Case Officer: Andrew Lewis

Recommendation: Approve

Proposal: Reserved Matters to 10/01642/OUT - Dorchester Phase 8A, comprising the provision of twenty four affordable residential units with associated landscaping, car parking, infrastructure and external works

VEHICLE TRACKING LAYOUT

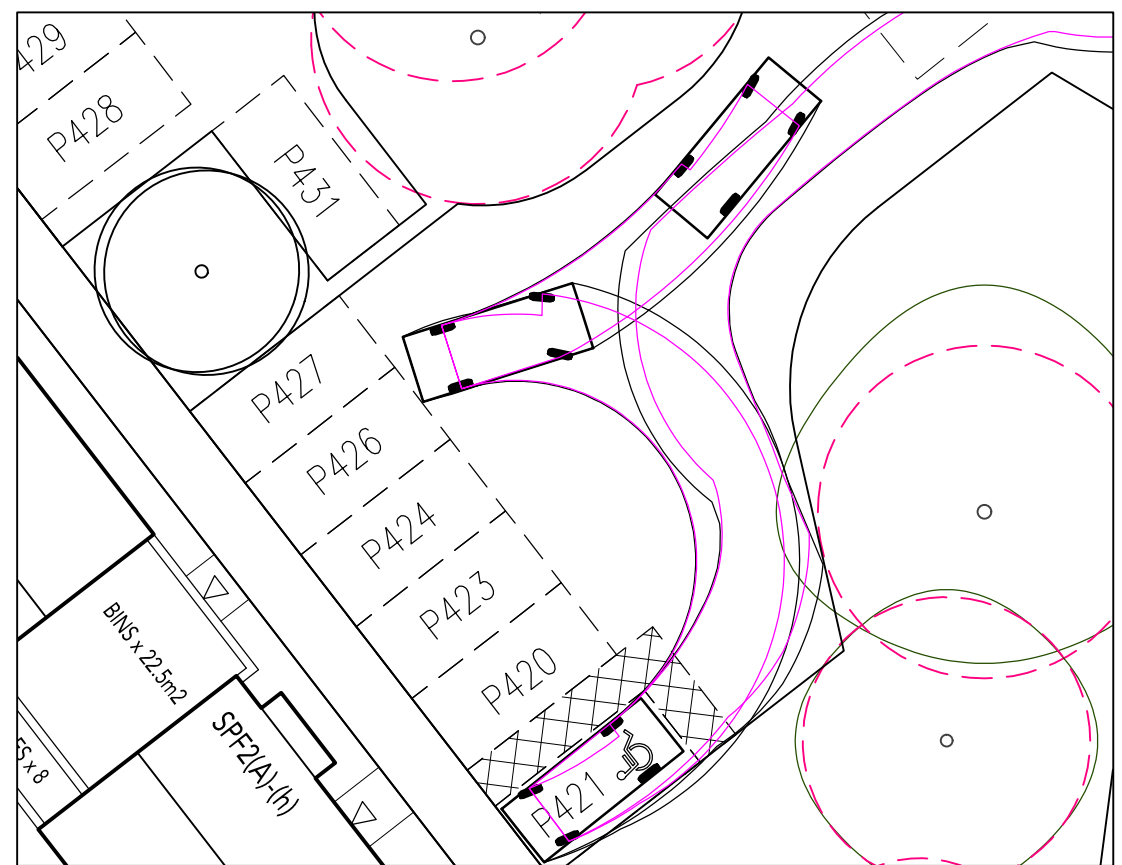
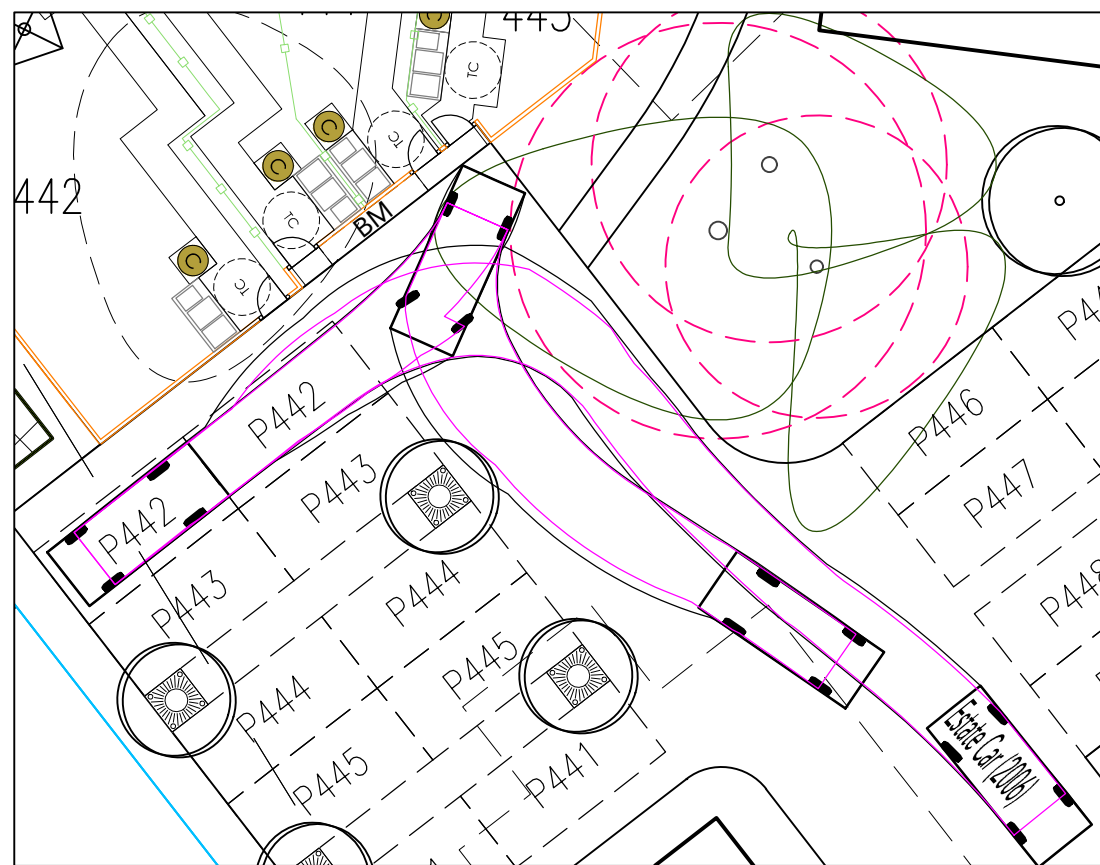
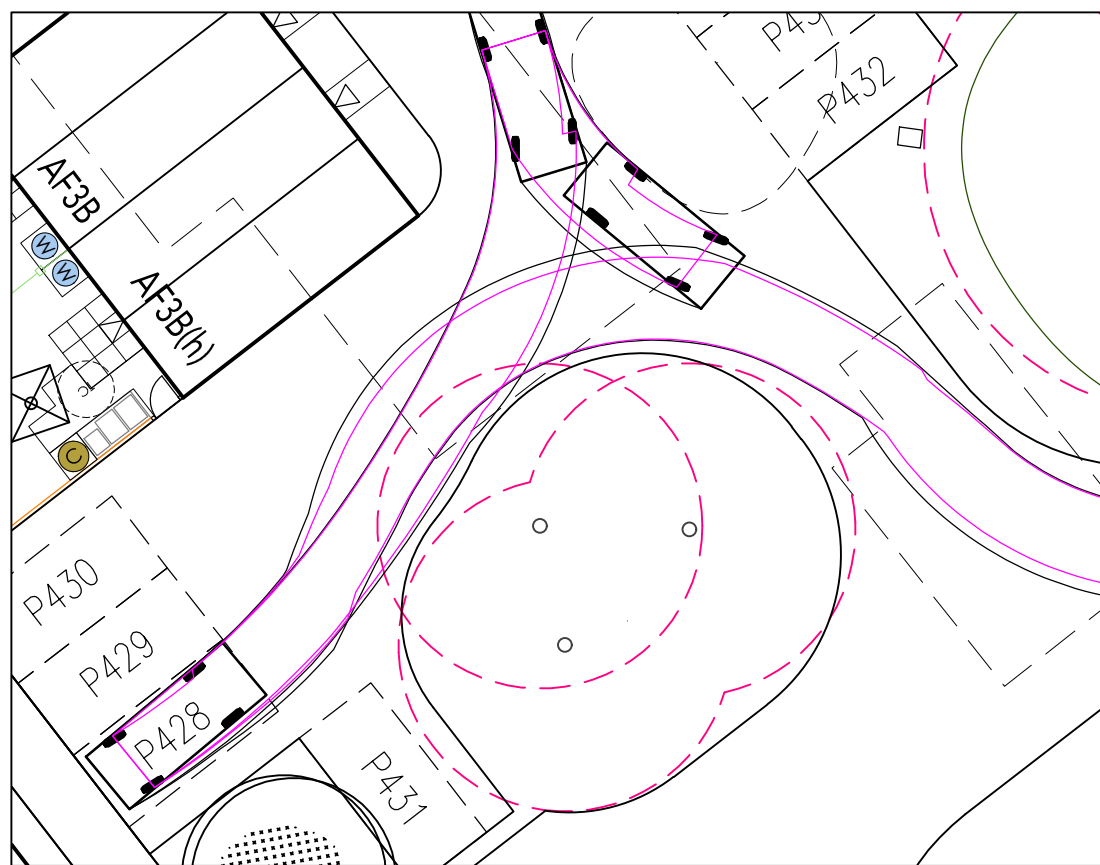
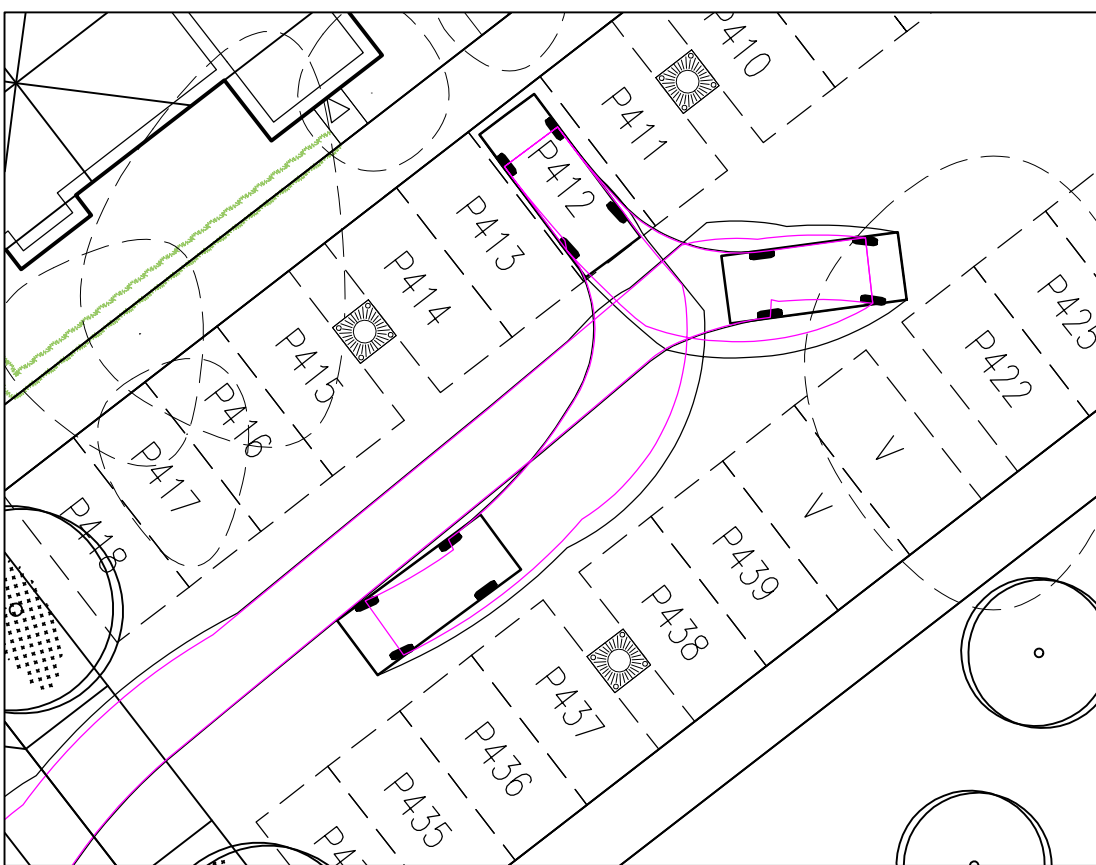
Response received, objection. Request for the footway access to be extended to meet the vehicle access and the tracking shows some areas of overhang and overrun of kerbs. Should permission be granted despite the objection from OCC Highways, conditions and informatives are recommended relating to vision splays, estate access, driveways and turning areas, cycle and parking provision and s.278 agreement for vehicular access works.

8.29. Whilst it is noted that Oxfordshire County have objected on the grounds that the footpath should connect to the vehicular access and that the tracking plans should be revised, these did not form part of the earlier approval. Given that the proposal would not result in a significant alteration to the layout of the approved development 16/00864/REM it is considered unreasonable to request these changes as part of the current application.

8.30. The development follows the masterplan and the Design Code in terms of the access arrangements with shared accesses between properties. The aim of the design code is to promote a greater continuity of frontage and considers rear parking acceptable here. Each house has two parking spaces. The flats have access to thirteen parking spaces. Visitor parking is provided to the rear within the courtyard. Plans of the tracking have been submitted and although objected to by the County Council they are similar to before. The County recommend the use of conditions if the scheme is approved.
